PRE-HEARING STAFF ANALYSIS

Rezoning Petition No. 2005-129

Location: Approximately 140.8 acres located northeast of the intersection of Hucks Road and Arthur Davis Road

Request: Change from R-3 and R-4 (single family residential), and I-1 (light industrial) to MX-3 Innovative (mixed-uses)

TECHNICAL DATA SHEET - ALTERNATIVE 'A'

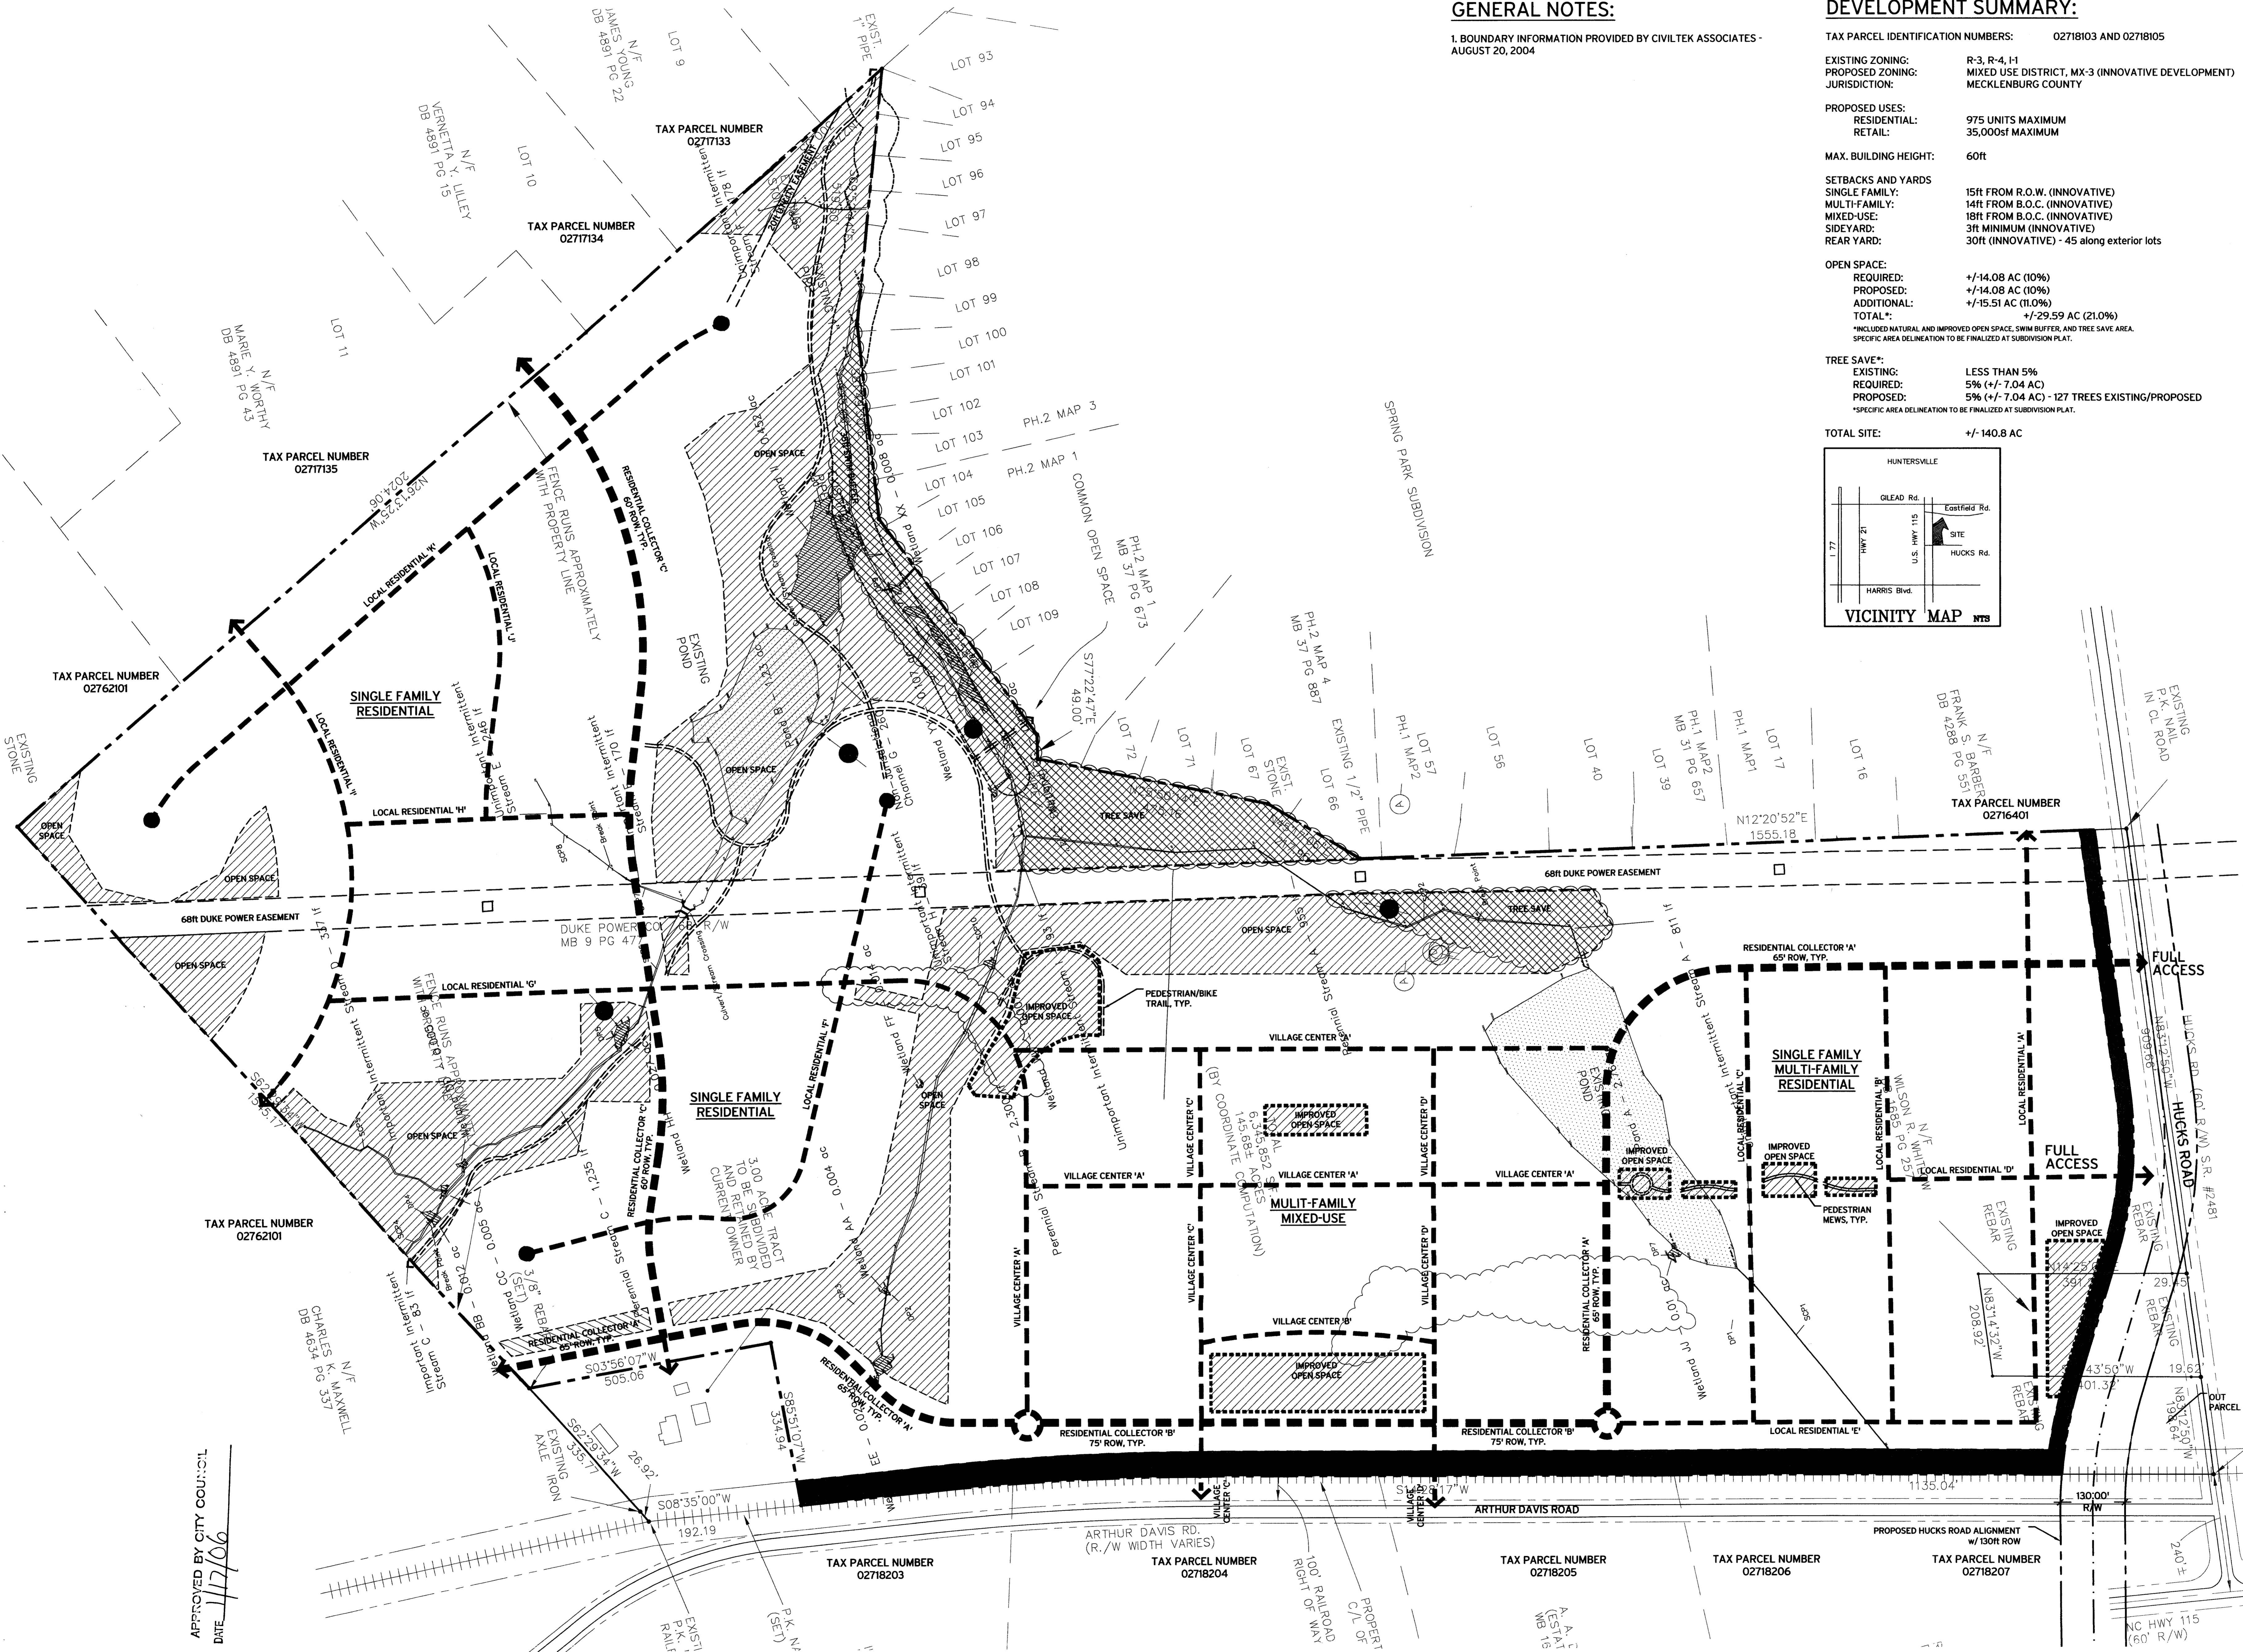
- The Technical Data Sheet shows a collector right-of-way of 69 feet for Residential Collector “B” but the cross-section shows only a 75-foot right-of-way. The larger cross-section is needed. Other cross-sections exist but there are no roads designated as such on the site plan. The site plan and the notes need to be consistent.
- CDOT’s transportation issues need to be resolved, including NCDOT maintenance of public streets.
- The landscape buffer along Hucks Road needs to be dimensioned to 36 feet, which is the smallest width that a six-foot berm can be accommodated within.
